Rezoning Transportation Analysis

Petition Number: 2023-036

From: Jake Carpenter, PE
Jacob.carpenter@charlottenc.gov
980-221-5675

Date	Description
7-26-23	First Review (TM)
10-26-23	Second Review (TM)
11-30-23	Trip Generation Update

RZ-2

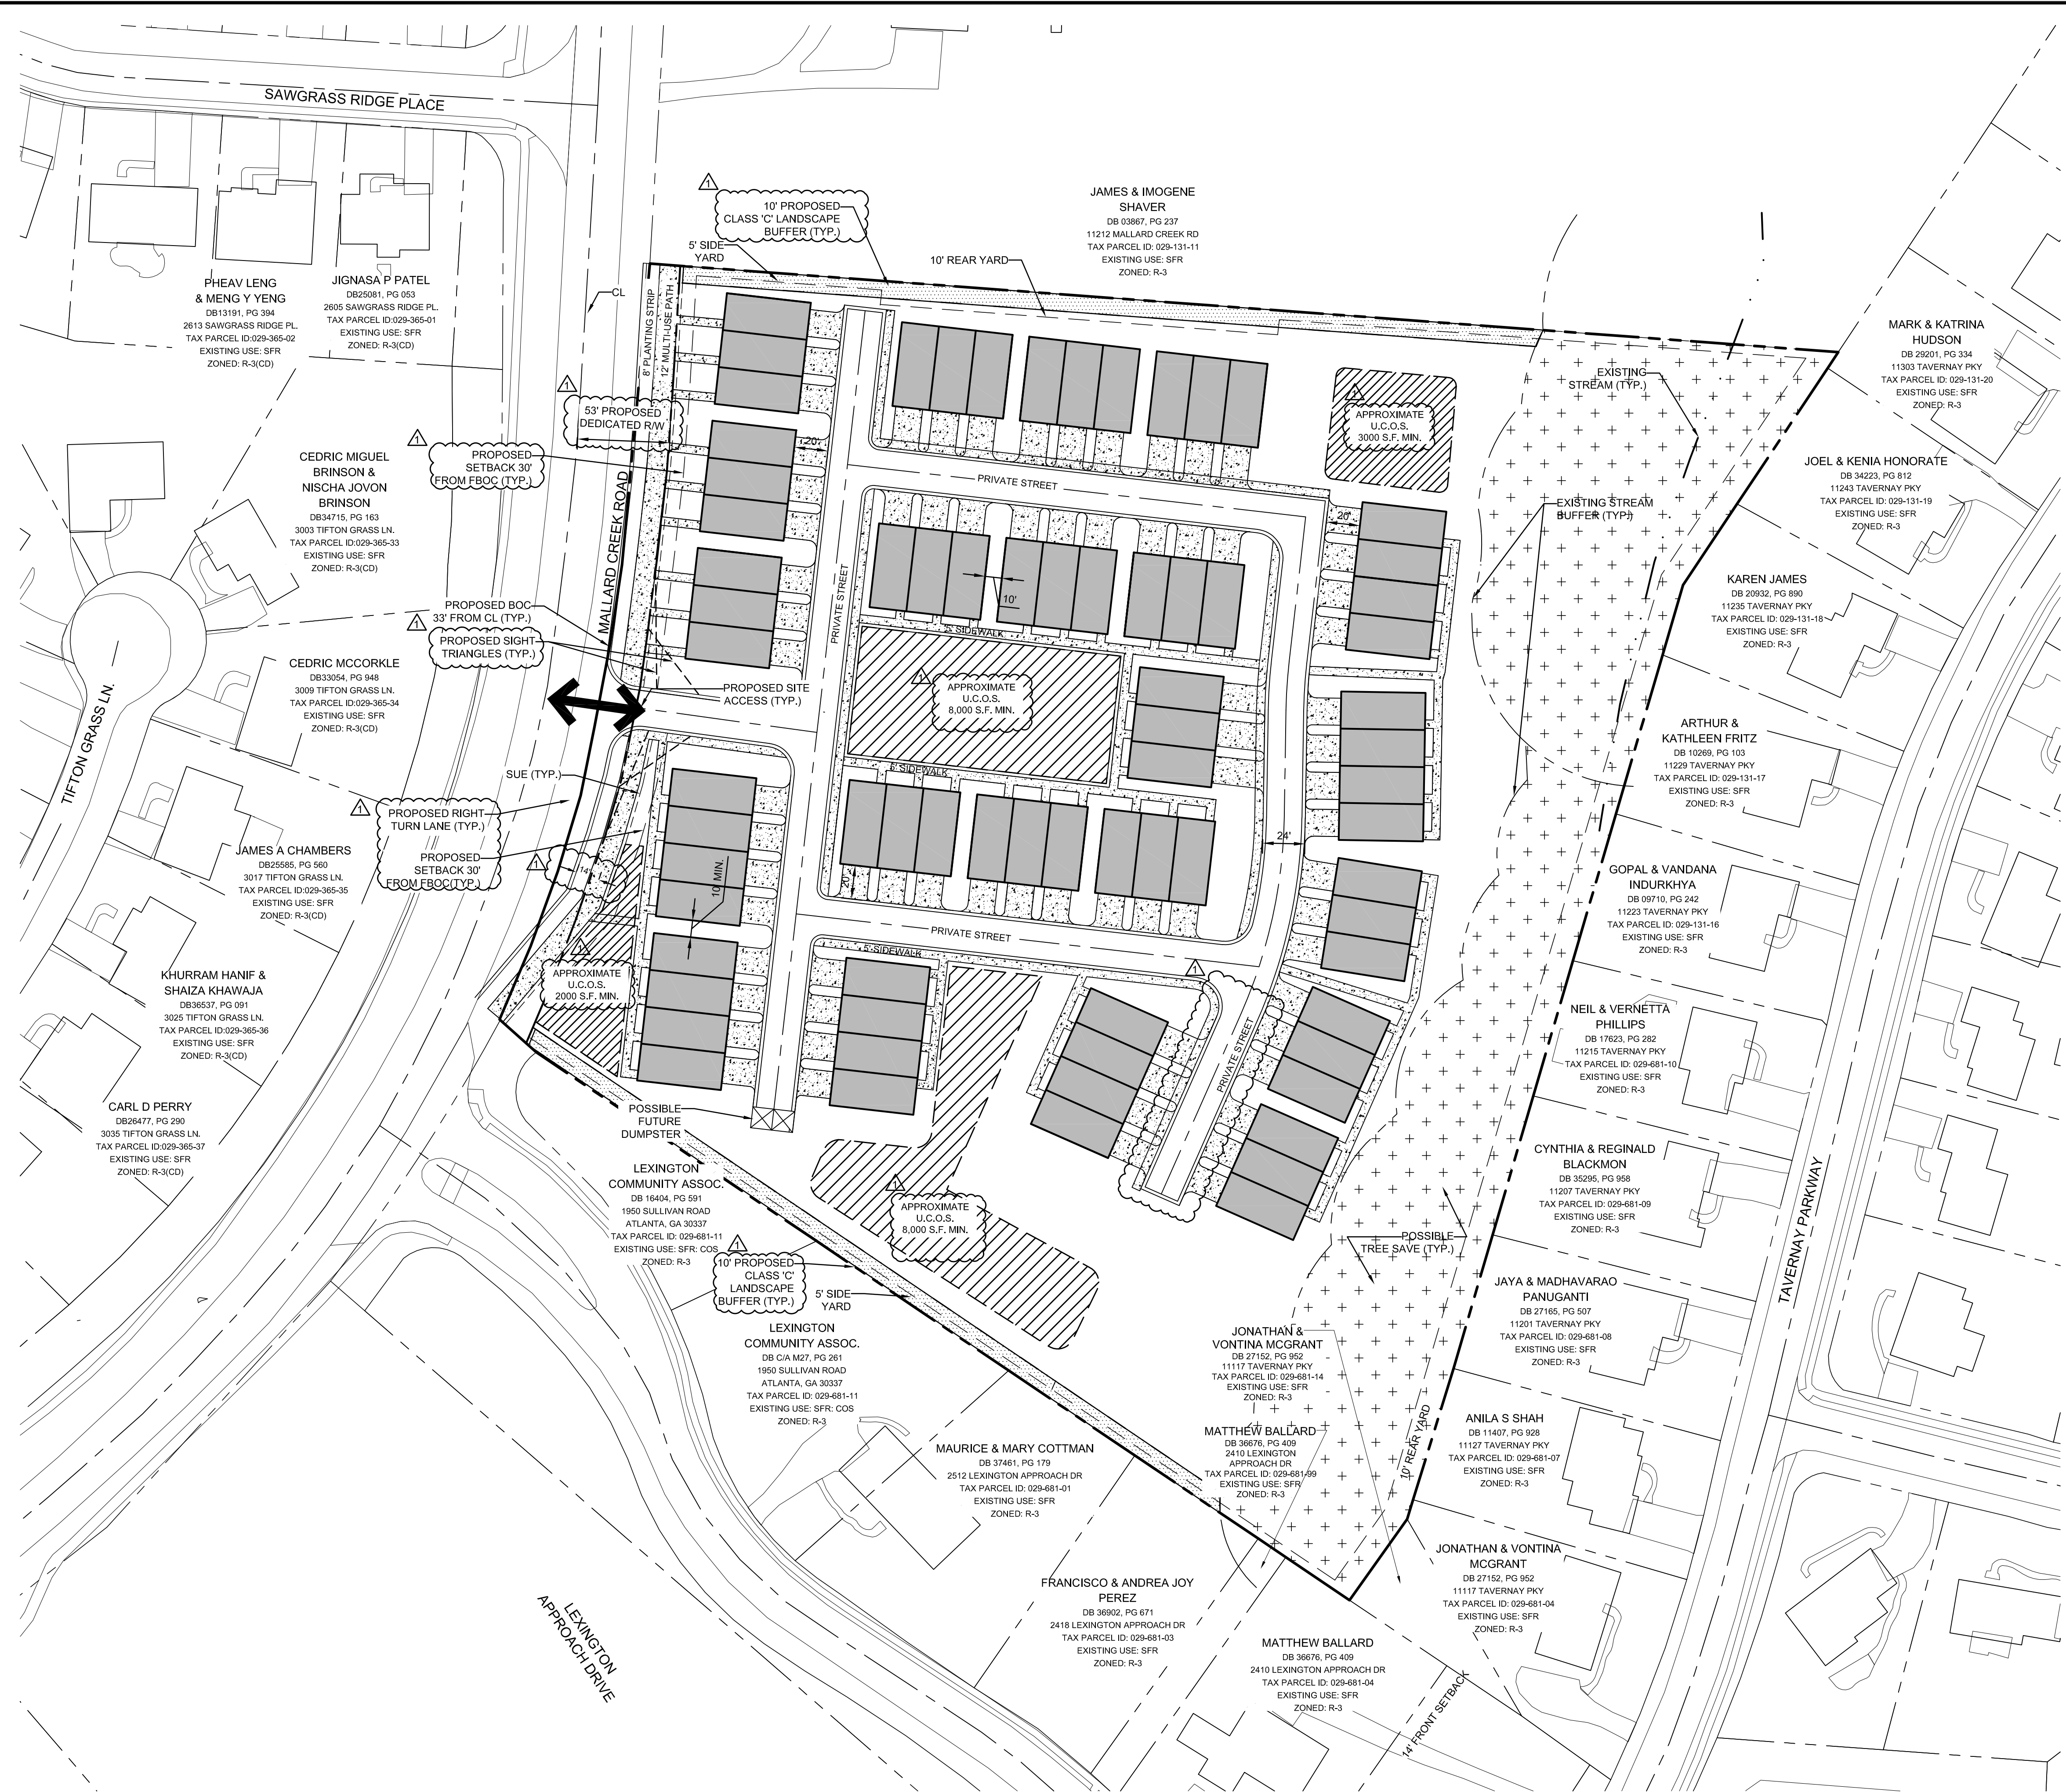
- a. ~~**Mallard Creek Road:** Location of curb and gutter to be coordinated with NCDOT STIP U-6028 to accommodate the STIP project along with Charlotte Streets Map with a roadway typical section of 4+ Boulevard with a Shared Use Path.~~

~~Label and dimension the curb and gutter from the centerline for each road on the site plan.~~

- 4. ~~Revise site plan and conditional note(s) to commit to coordinating with NCDOT regarding STIP U-6028. Site plan shall show U-6028 on the rezoning plan.~~

- 5. ~~Revise site plan and conditional note(s) to commit to constructing a dedicated right-turn lane into the site with 100-feet of storage in coordination with NCDOT.~~
